LISTED BUILDING CONSENT

Application Reference: DC/23/03589

Application for Listed Building Consent - Erection of a barn (following demolition of shed and oil tank); internal and external works to the main building; repairs to boundary walls and construction of front and side gates; new grass ground banks replacing bridge on moat; removal of rear balustrade walls; landscaping; installation of air source heat pump system and PV panels on garage roof. As detailed within Schedule of Works.

Clopton Hall, Clopton Green, Rattlesden, Bury St Edmunds Suffolk IP30 0RN

Drawing:
Staircase S5 & S6 Plan Details

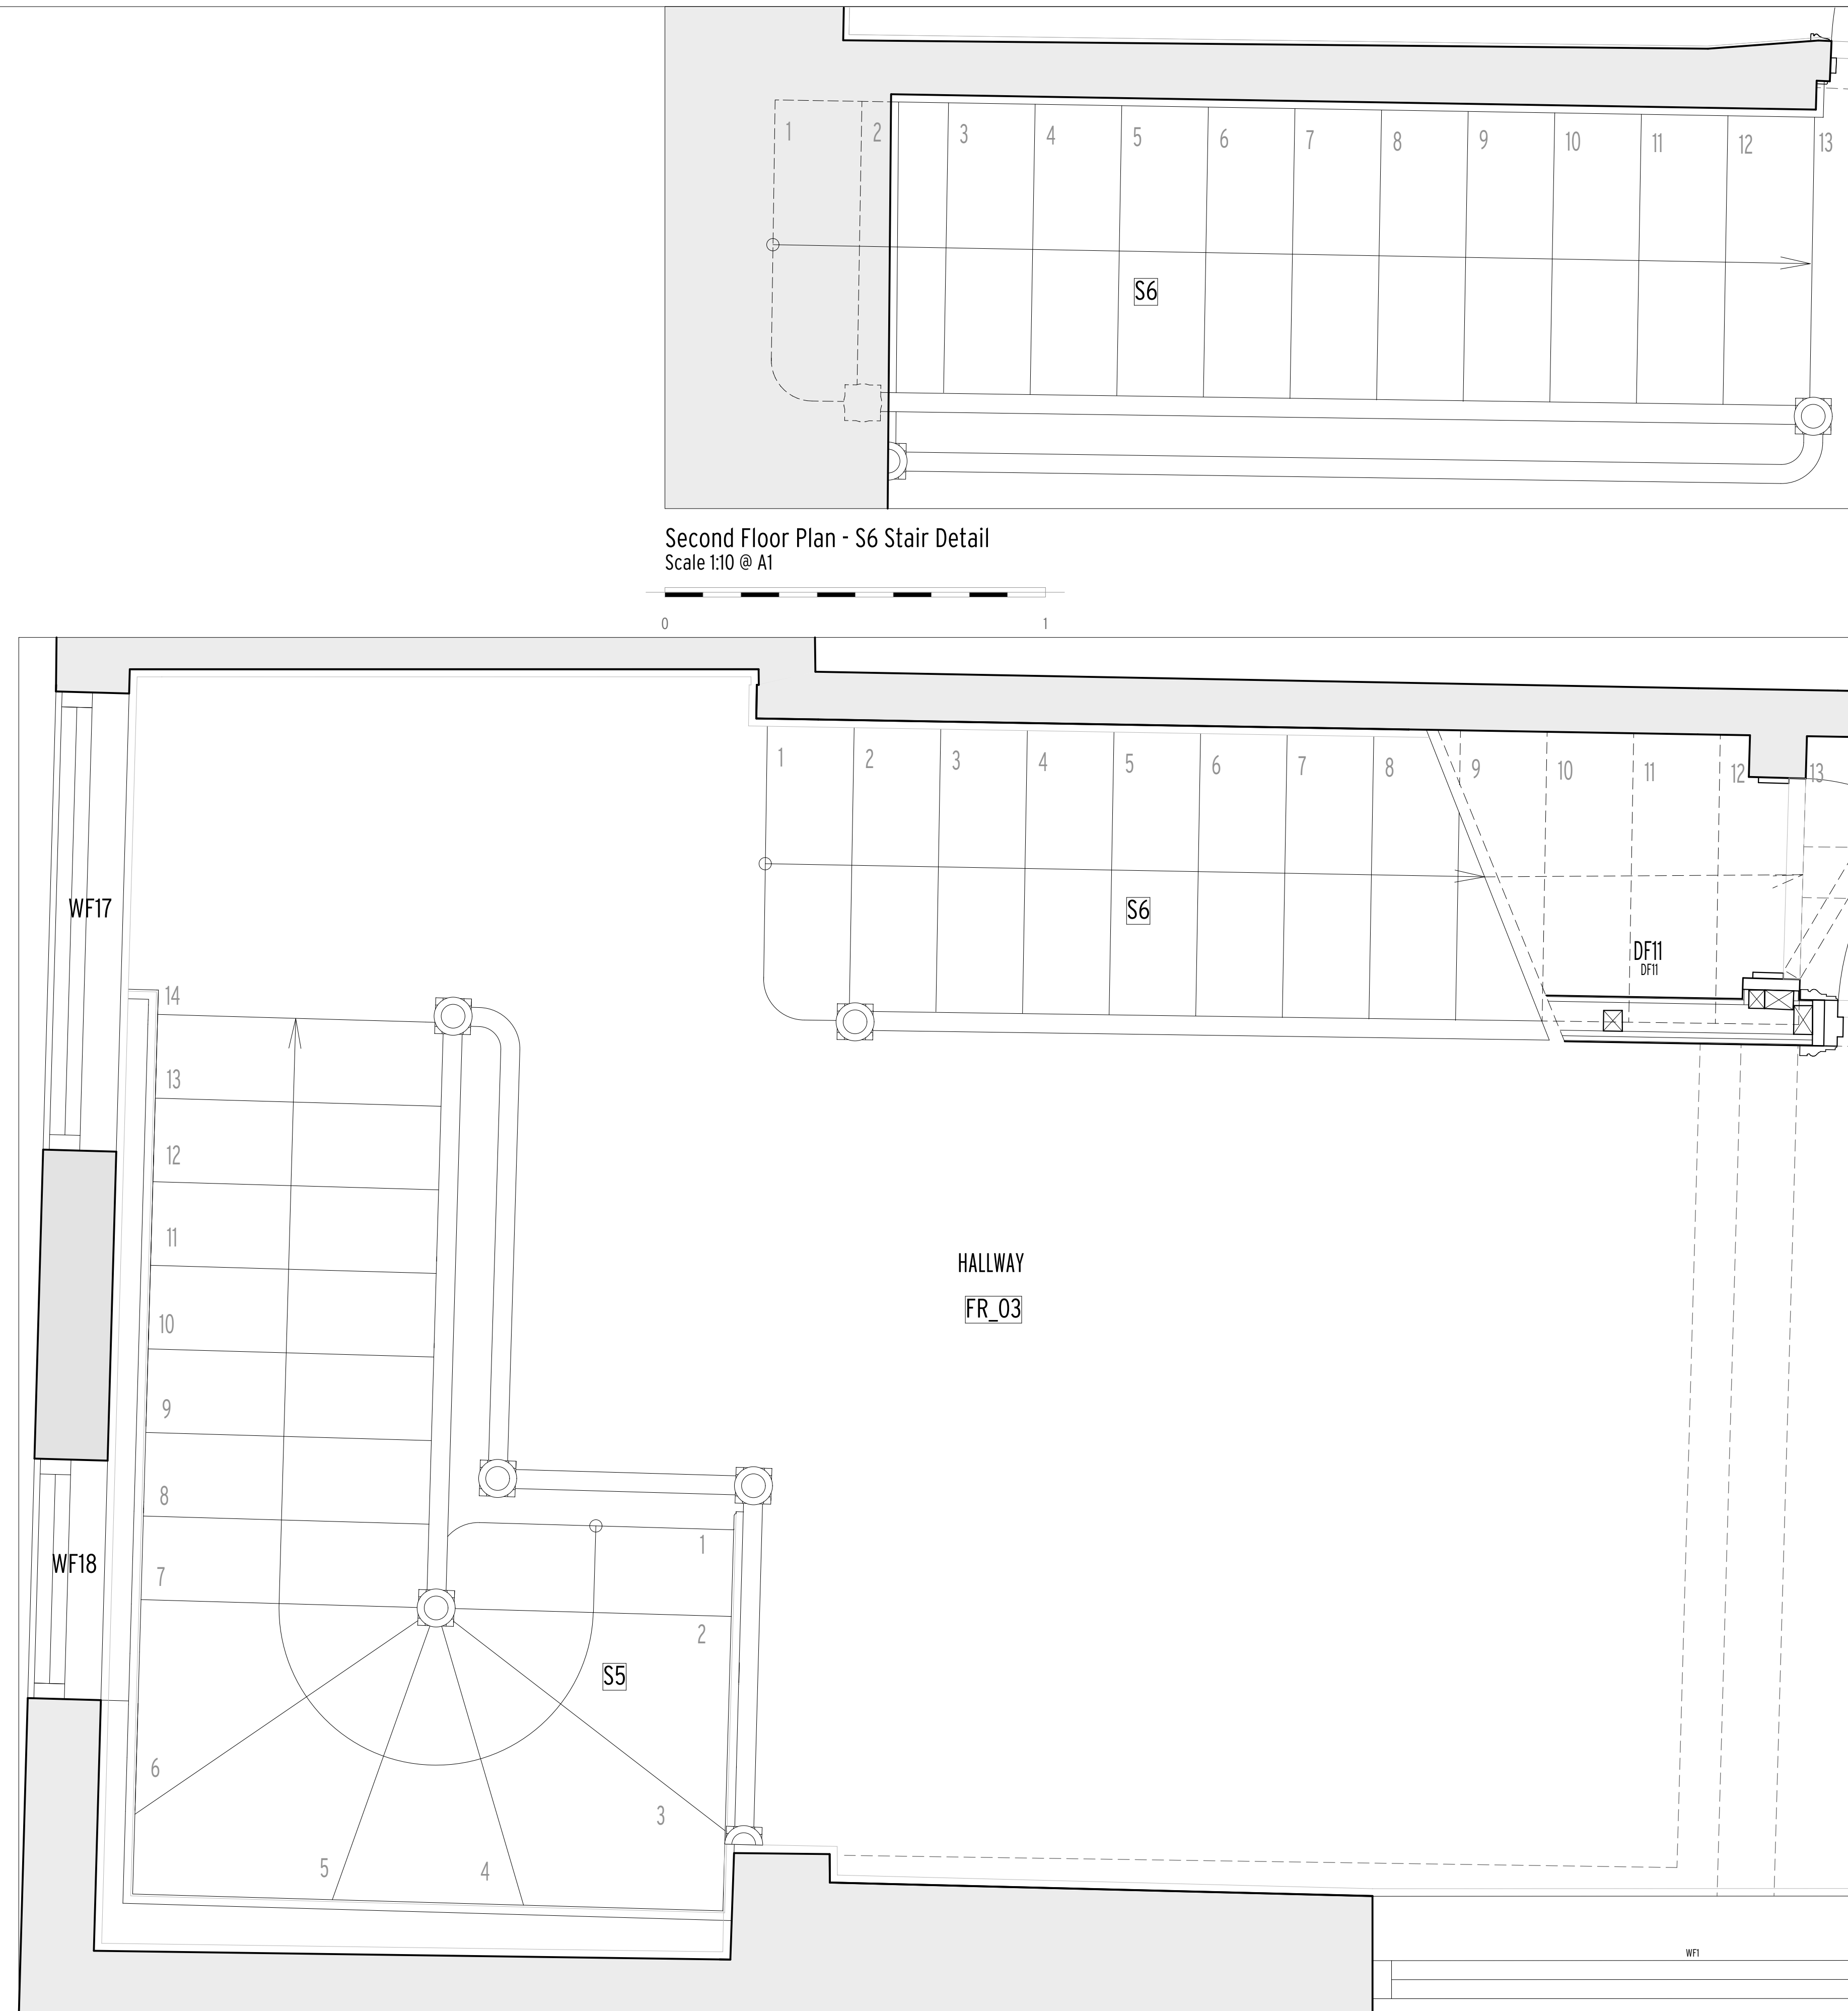
Prior to the installation of the new staircase on the hereby approved development, detailed elevation and section drawings which shall include details of materials, joinery finishes and colour of the staircase and their surrounds to be installed shall be submitted to and approved, in writing, by the Local Planning Authority and shall thereafter be entirely installed as approved.
